Harnett County Government Complex
307 W. Cornelius Harnett Boulevard
Lillington, NC 27546

Re: Status of Improvement Permit Application # 15-5-36733

An attempt was made to evaluate your property for the purpose of issuing an Improvement Permit. The evaluation could not be completed for one or more of the following reasons.

Site Plan for  
Gary + Tangia D Millsap

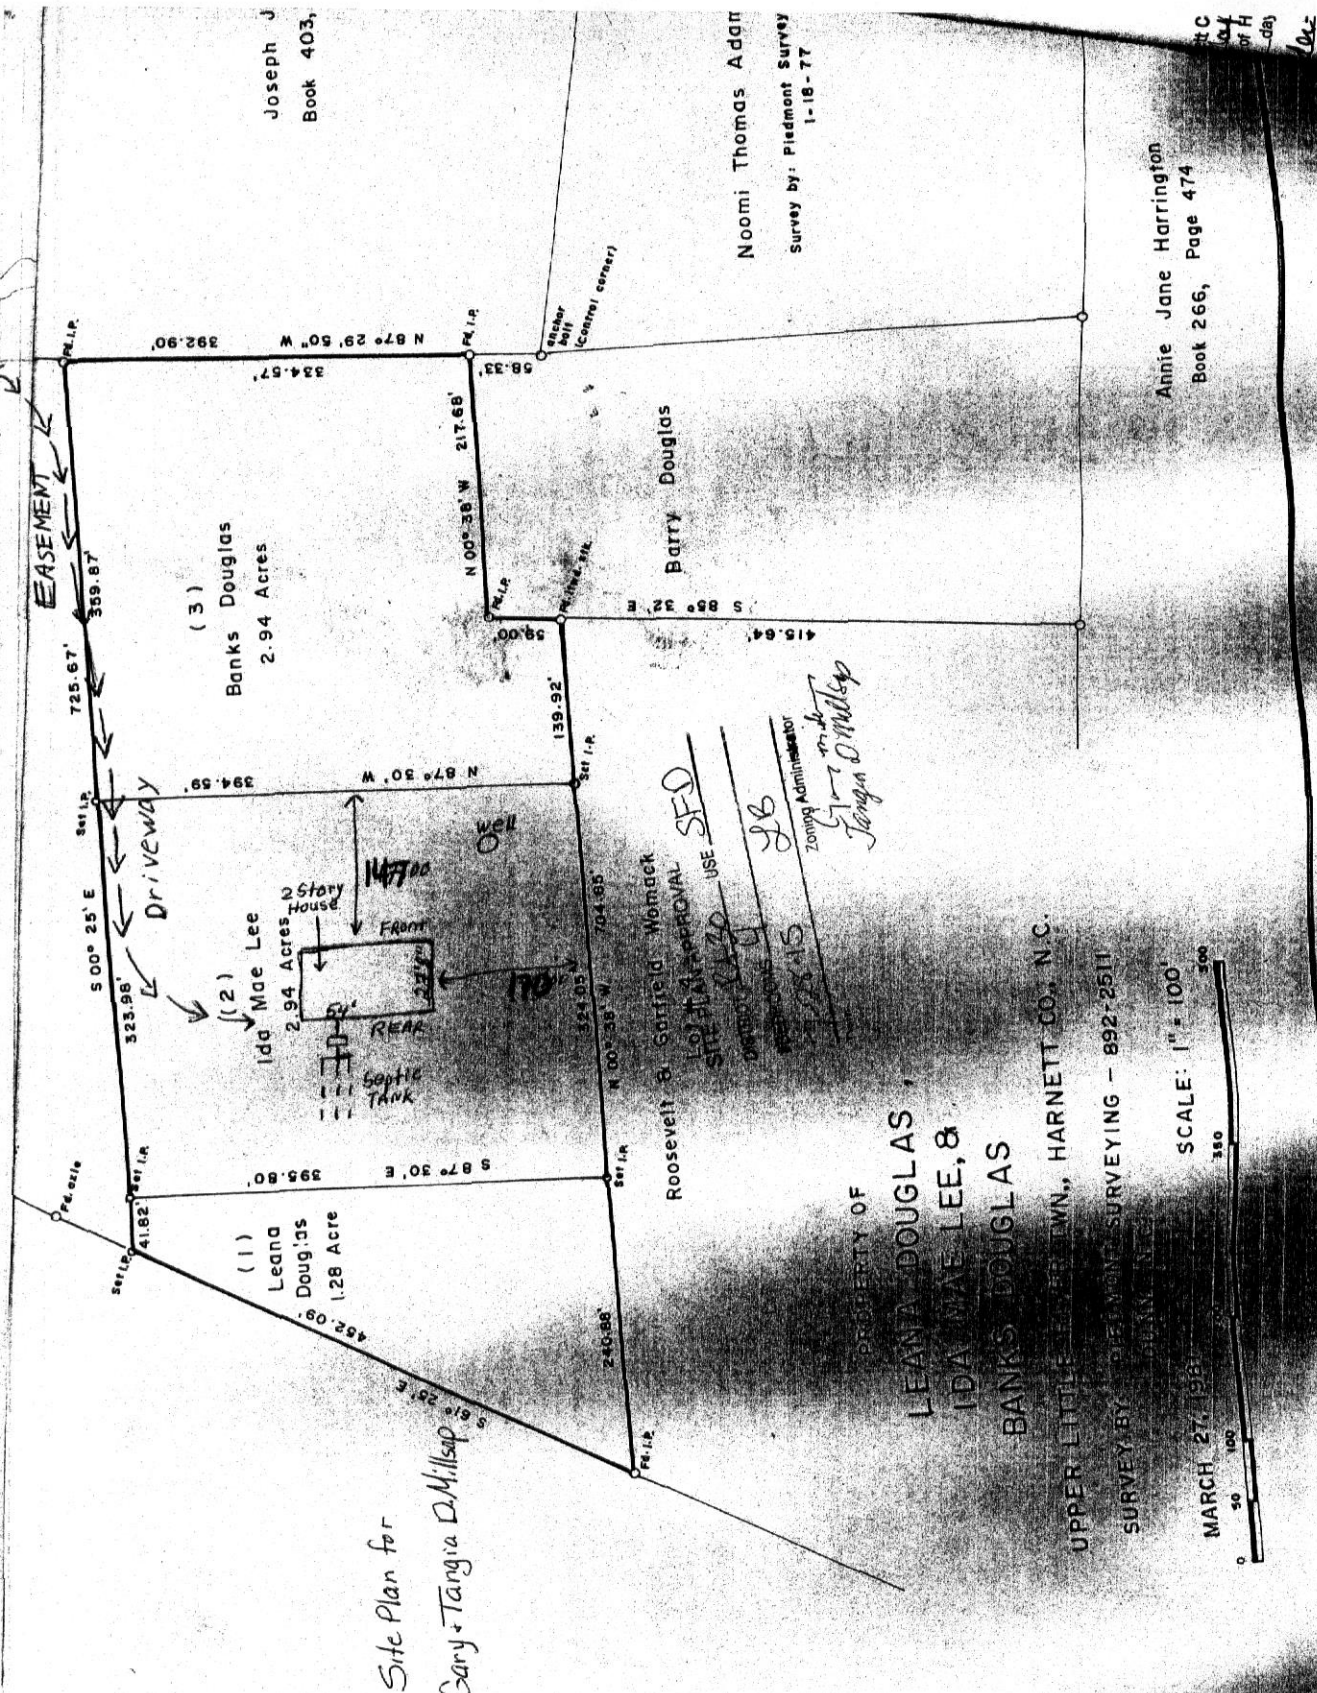
- 1. Use pink flags to mark property lines and irons that are set by surveyor need to be visible *(\$25.00 fee incurred)*
- 2. Use orange flags to mark house corners *(\$25.00 fee incurred)*
- 3. Directions not clear to property *(\$25.00 fee incurred)*
- 4. Property needs only brush or vegetation removed
- 5. Driveway not shown on site plan
- 6. Backhoe pits required
- 7. Other – Revise site plan to match house flags on property.
